Project Name CUNADO RETAIL CENTER

CITY OF ALBUQUERQUE  
PLANNING DEPARTMENT  
May 16, 2007  
DRB Comments

RE: Cunado Retail Center/final plat

DEVELOPMENT REVIEW BOARD – SPEED MEMO

LANDFILL DISCLOSURE STATEMENT

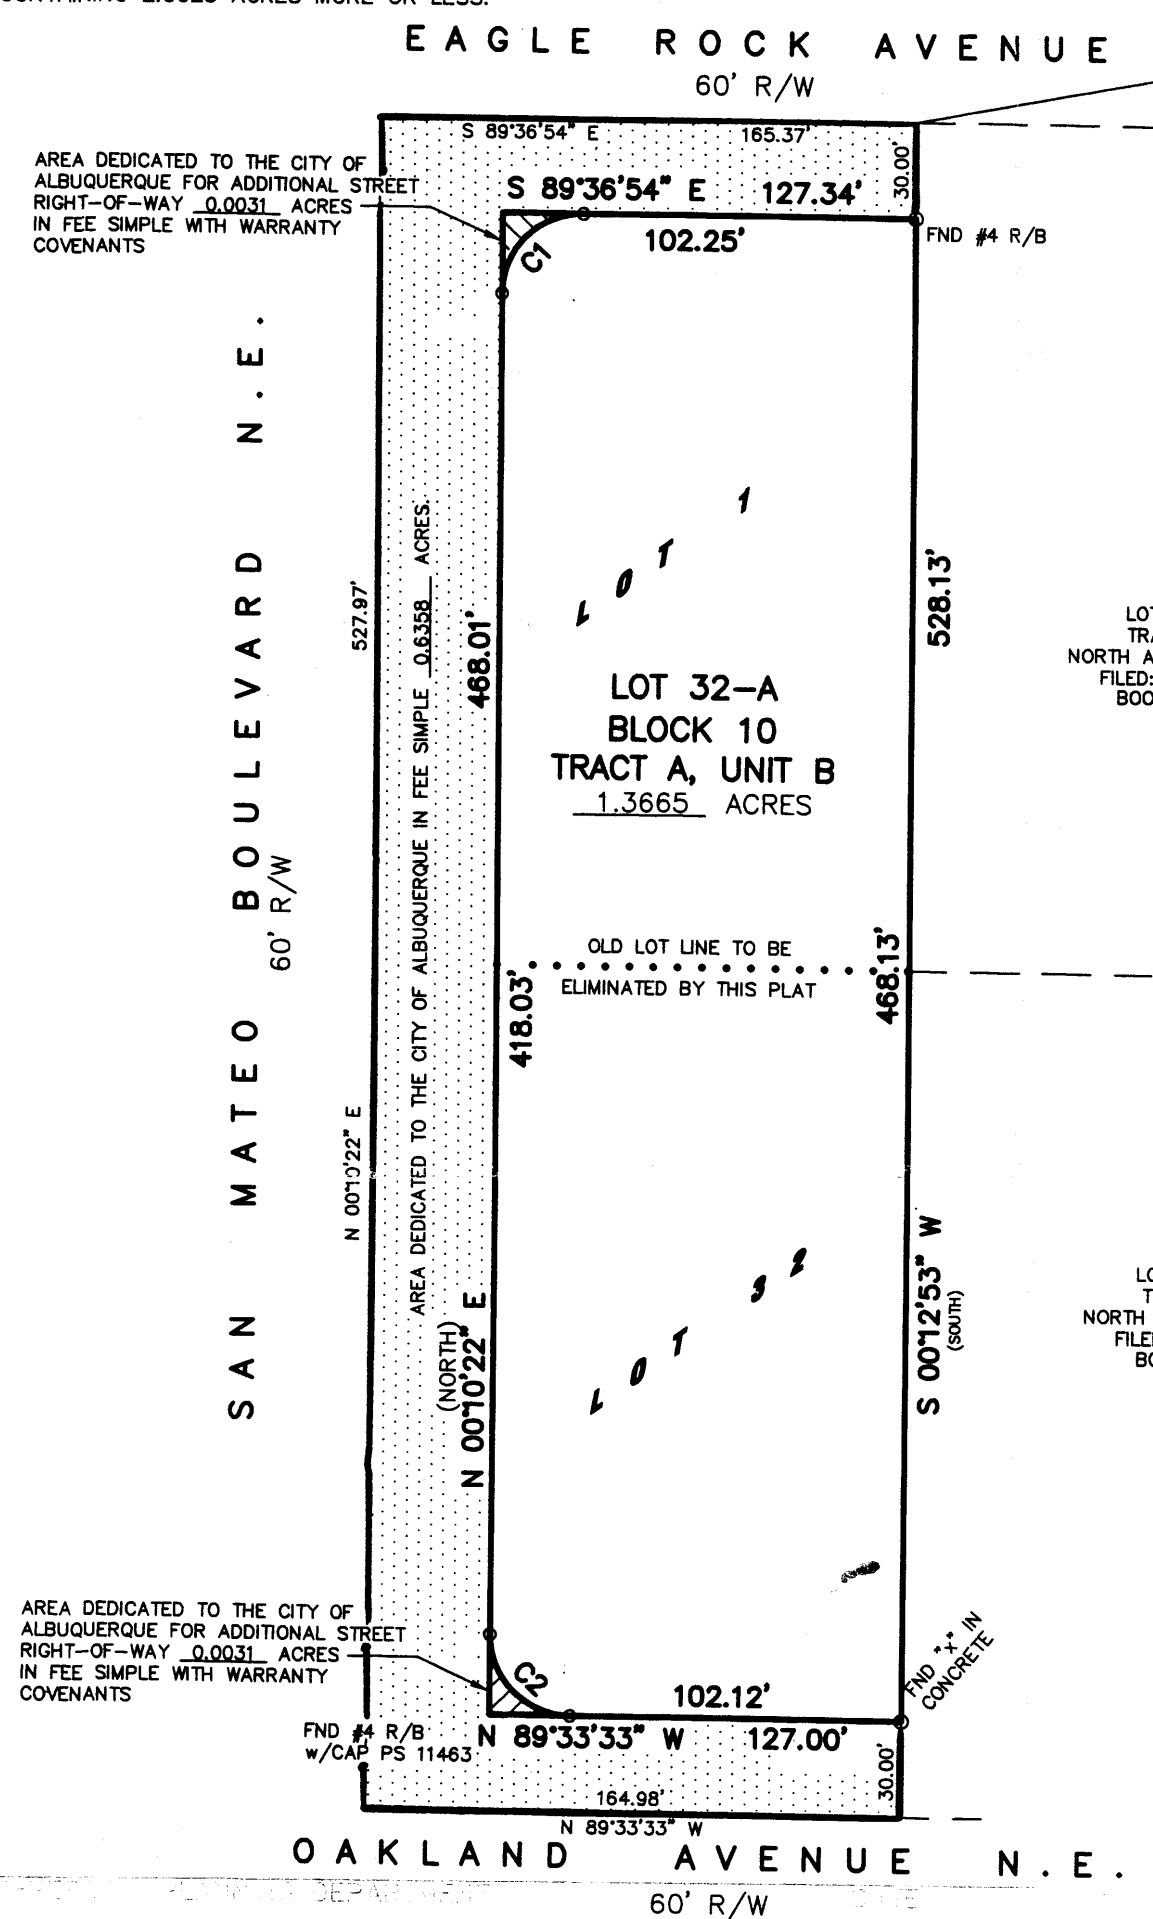
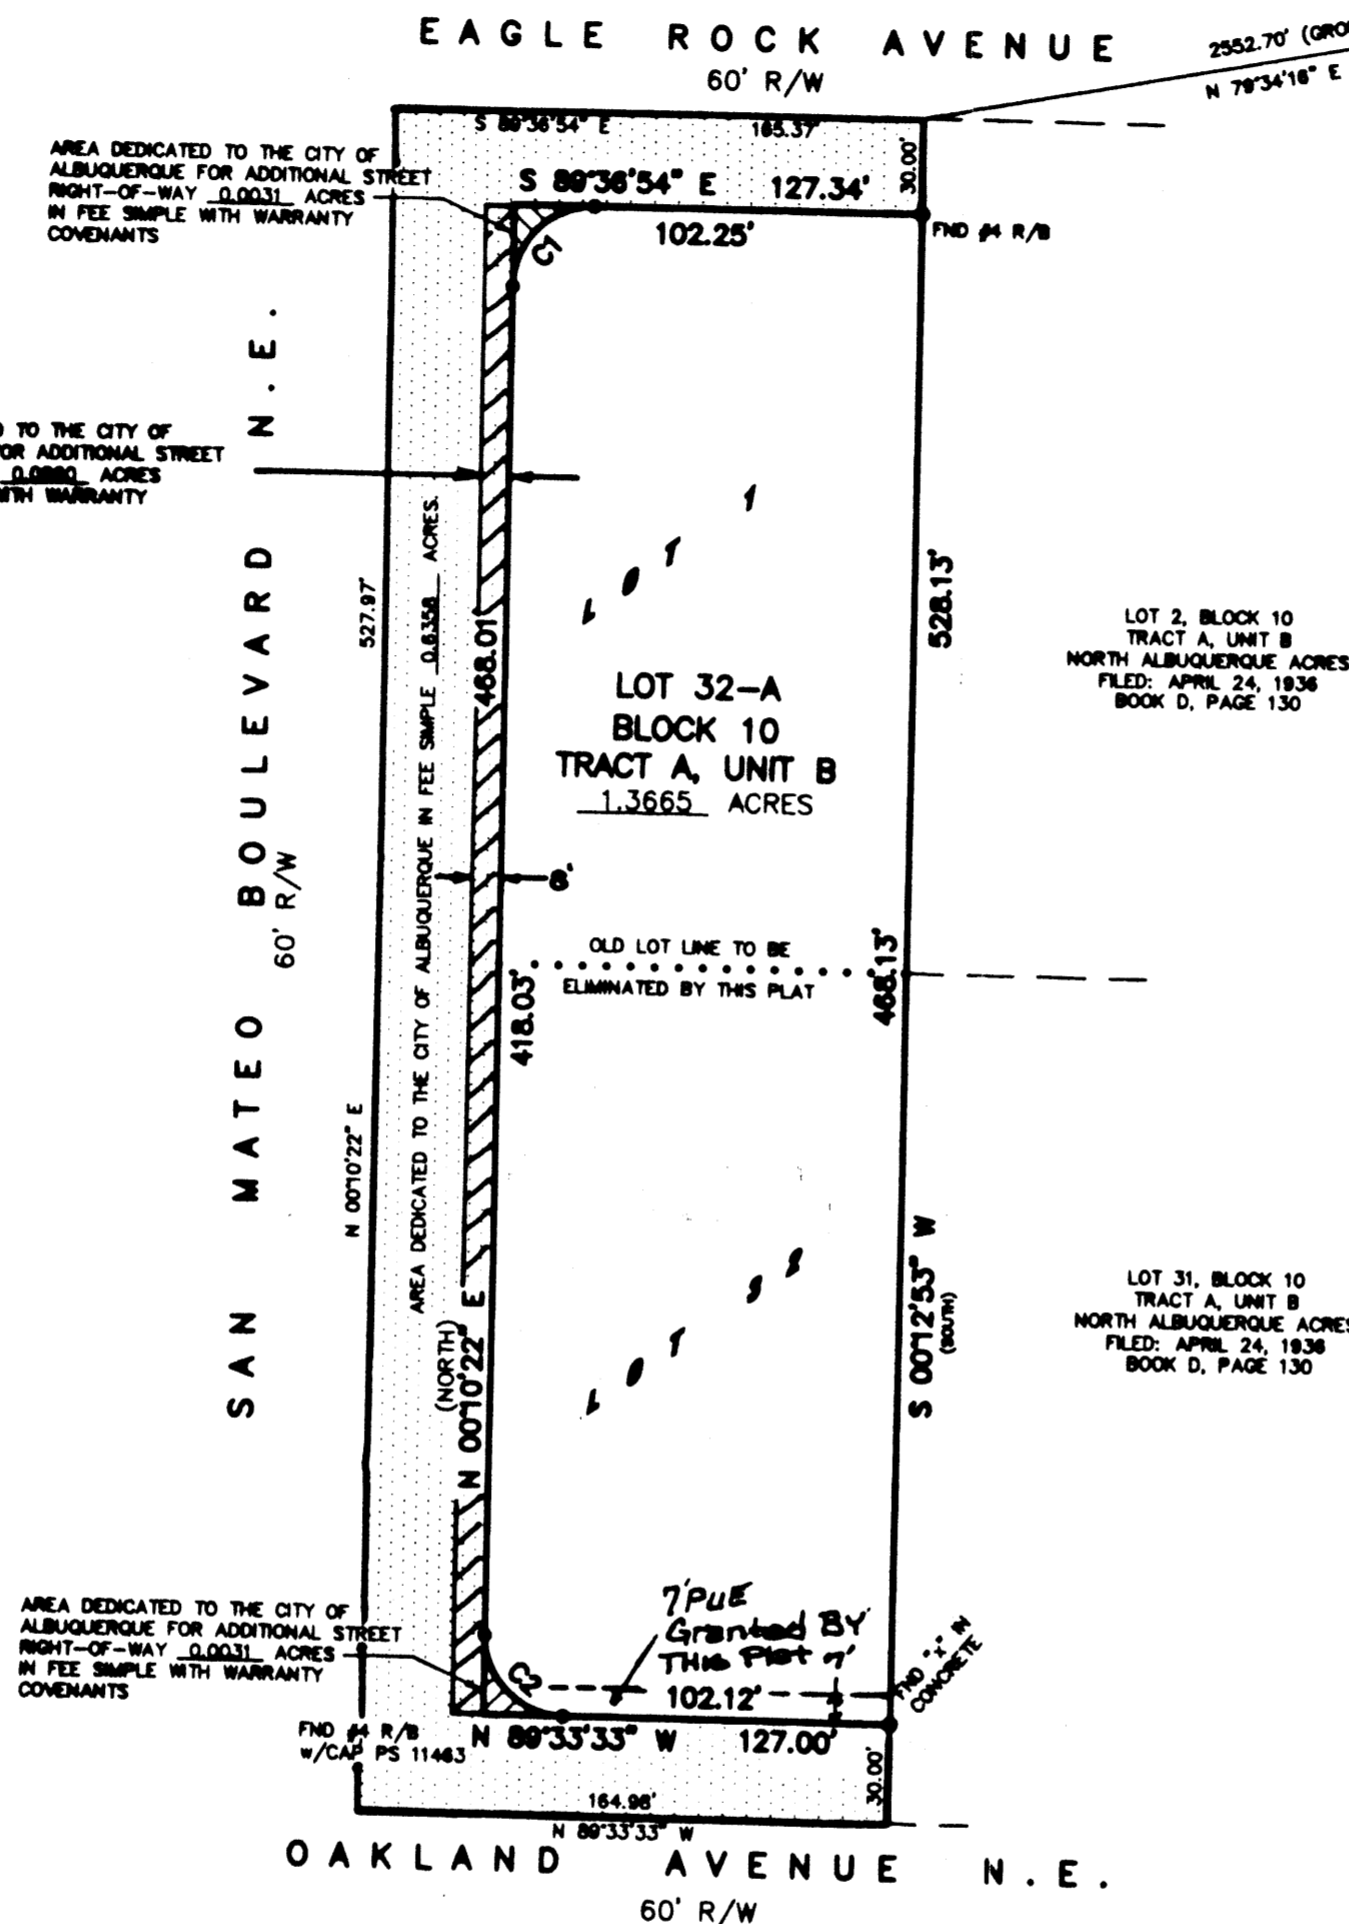
City Environmental Health must sign the plat before Planning signs due to the proximity of a landfill site.
